Recommendation Report for Planning Permission for Works or Extension to a Dwelling

REF NO: BR/99/22/HH

LOCATION: 21 Shelley Road
Bognor Regis
PO21 2SL

PROPOSAL: Roof extension and conversion of loft to habitable use including the installation of 1 x rear dormer and rooflights.

DRAWING TITLE
Proposed Floor Plans

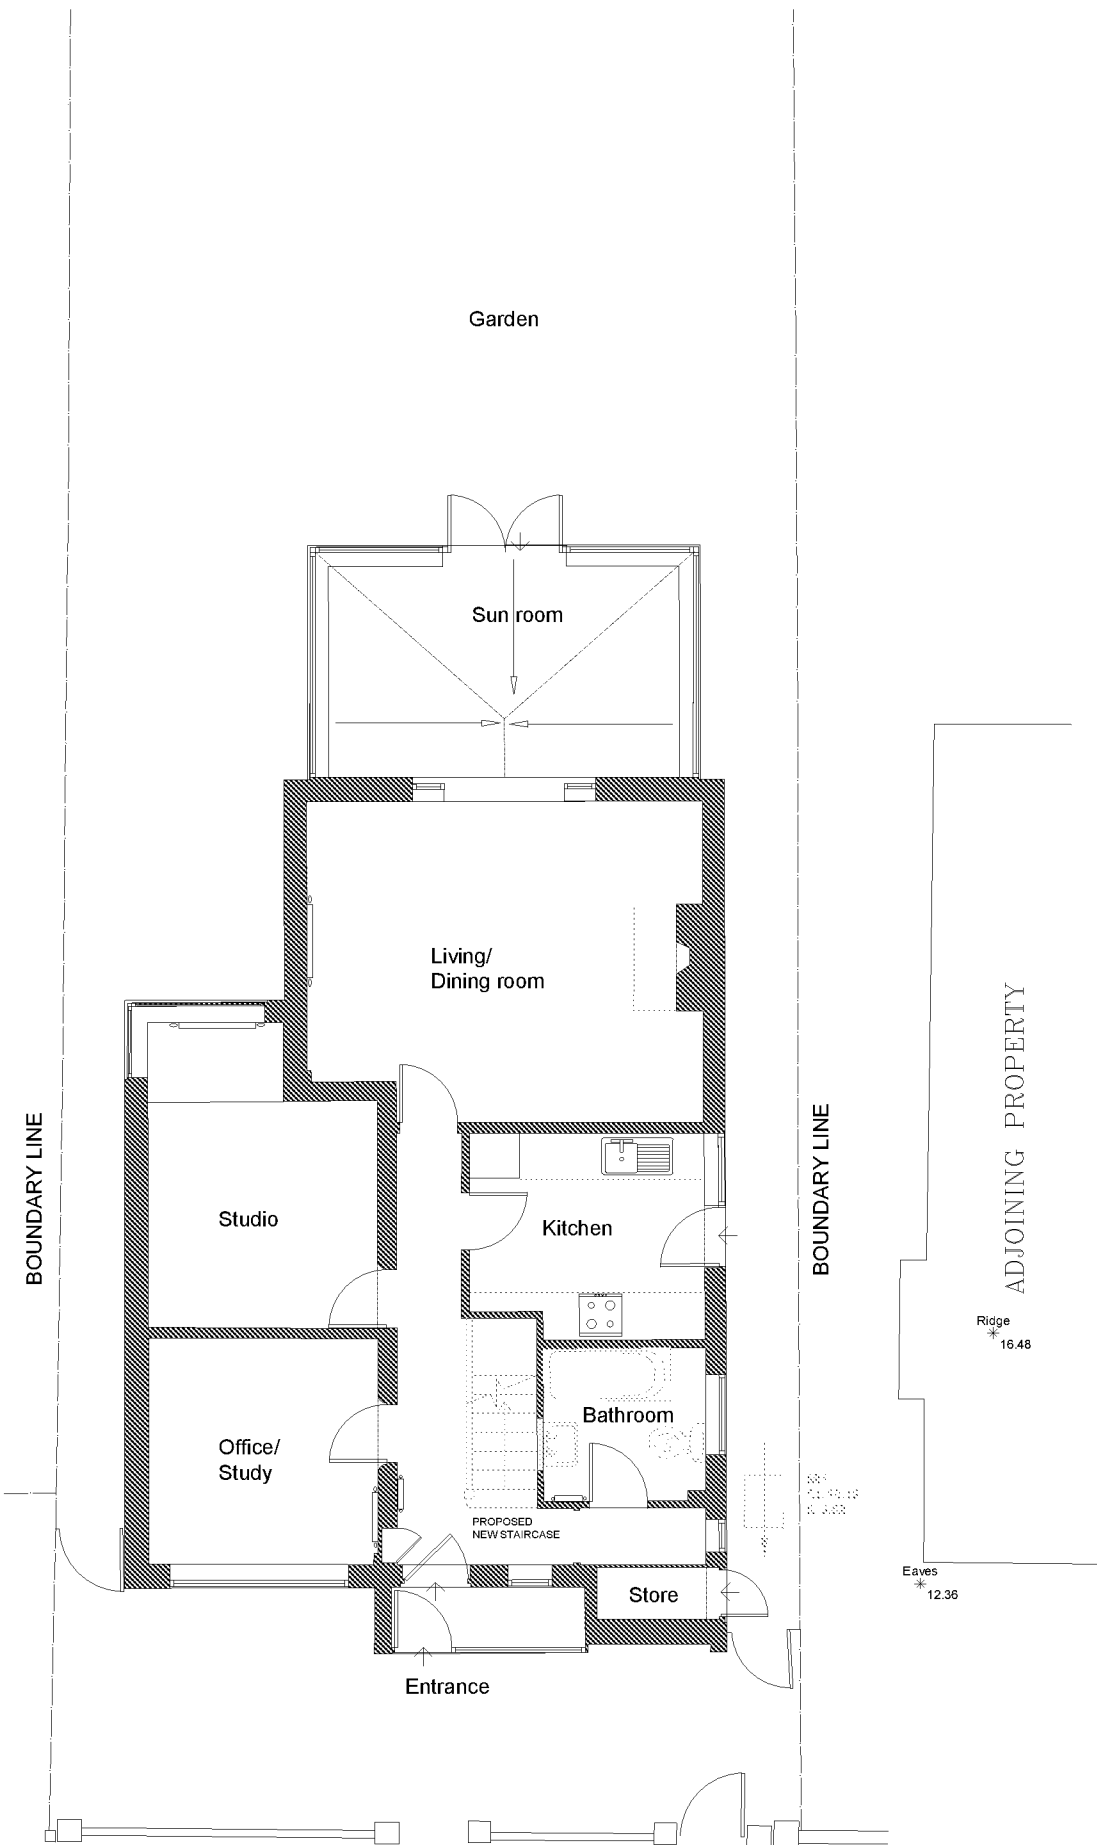
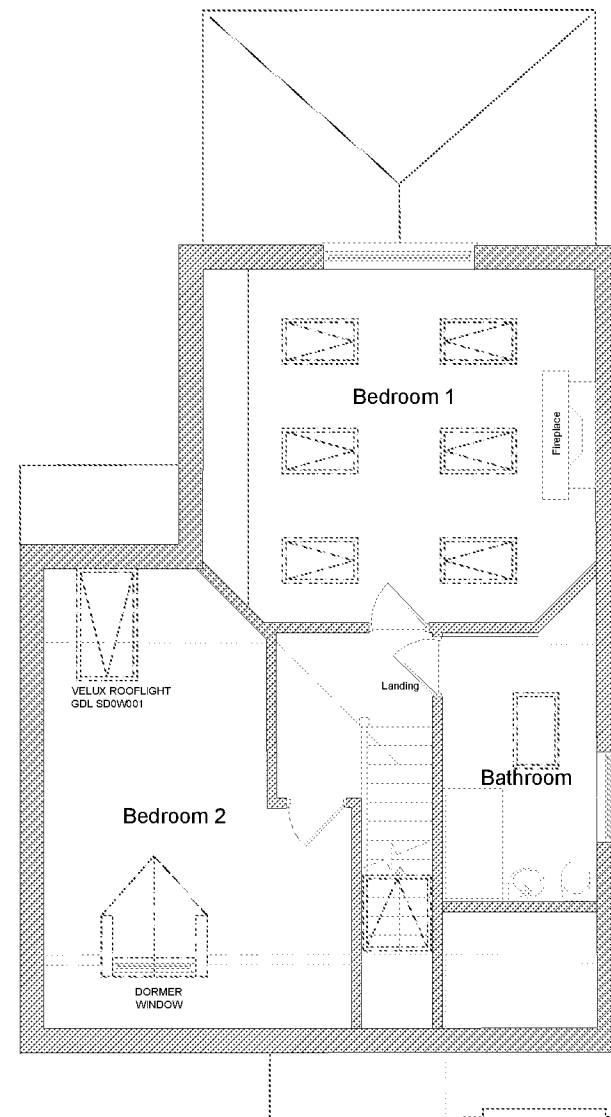
To the rear of the dwelling, a bedroom will be constructed in the roof slope which will result in an additional rear facing first floor window. This will give rise to views which are not currently achievable. However, this does not provide significant overlooking with views consistent with that achieved at neighbouring properties. There is sufficient separation to the rear boundary.

There are a number of rooflights to the rear which will have a possibility for views over neighbouring gardens when looking at a 45-degree angle. As such the two rooflights to the rear of the roof will be conditioned to remain obscured glazed and fixed shut to ensure views over neighbouring gardens is mitigated.

Reason: For the avoidance of doubt and in the interests of amenity and the environment in accordance with policy D DM1 of the Arun Local Plan.
- 3 The 2 rooflights to the southerly rear end of the dwelling, located to both sides of the roof

slope, serving a bedroom shall be obscured glazed and fixed shut.
